**Subject:** Rezoning Petition Review

**Rezoning Petition #:** 22-045

**Location of Property:** Approximately 14 acres located at the southwest intersection of Wheatley Ave and Ellington St, north of Billingsley Rd.

**Recommendations  
Concerning Storm Water:**

SCHEMATIC SITE PLAN

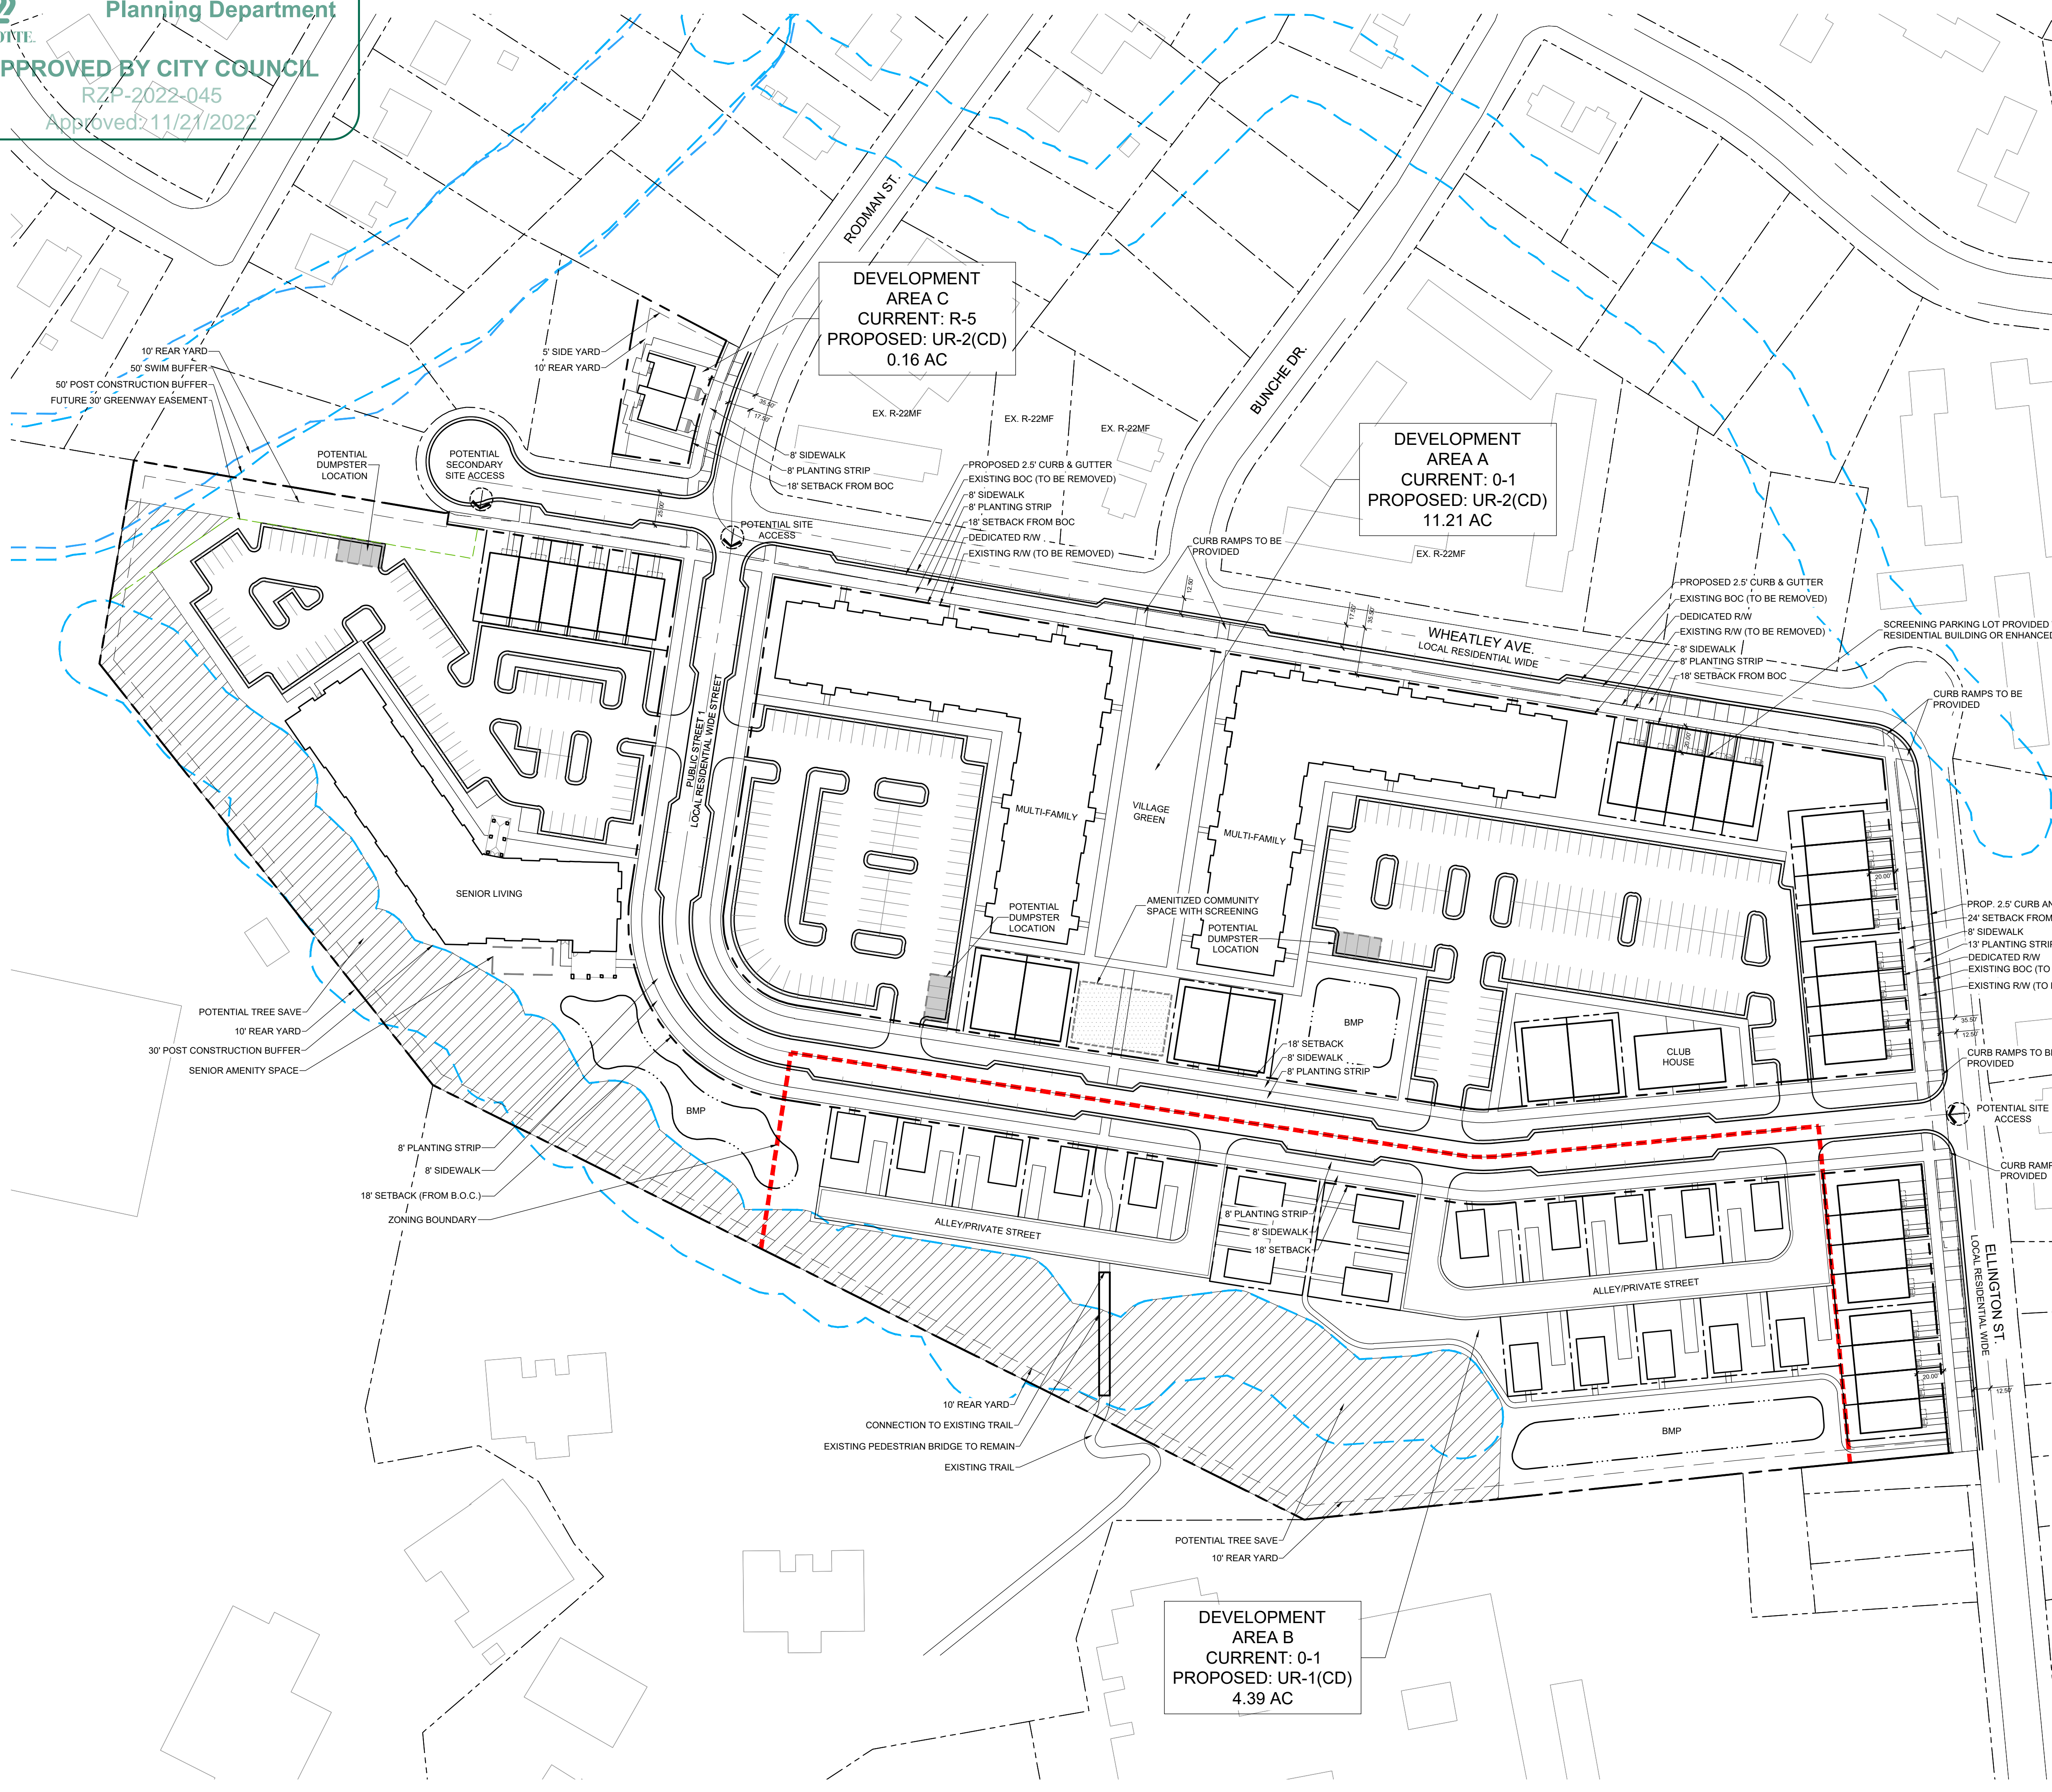
**This property drains to Briar Creek, which is an impaired/degraded stream, and may contribute to downstream flooding. This project has the opportunity to mitigate future impacts to this stream, therefore, Storm Water recommends placing the following notes on the plan:**

For defined watersheds greater than 24% built-upon area (BUA), construct water quality stormwater control measures (SCMs) designed for the runoff generated from the first 1-inch of rainfall for all new and redeveloped BUA associated with the project. SCMs must be designed and constructed in accordance with the Charlotte-Mecklenburg BMP Design Manual.

For defined watersheds greater than 24% built-upon area, control the entire volume for the 1-year, 24-hour storm for all new and redeveloped BUA associated with the project. Runoff volume drawdown time shall be in accordance with the Charlotte-Mecklenburg BMP Design Manual.

For commercial projects with greater than 24% BUA, control the peak to not exceed the predevelopment runoff rates for the 10-yr, 6-hr storm and perform a downstream flood analysis to determine whether additional peak control is needed and if so, for what level of storm frequency, or if a downstream analysis is not performed, control the peak for the 10-yr and 25-yr, 6-hour storms.

For residential projects with greater than 24% BUA, control the peak to not exceed the predevelopment runoff rates for the 10-year and 25-year, 6-hour storms or perform a downstream analysis to determine whether peak control is needed, and if so, for what level of storm frequency.
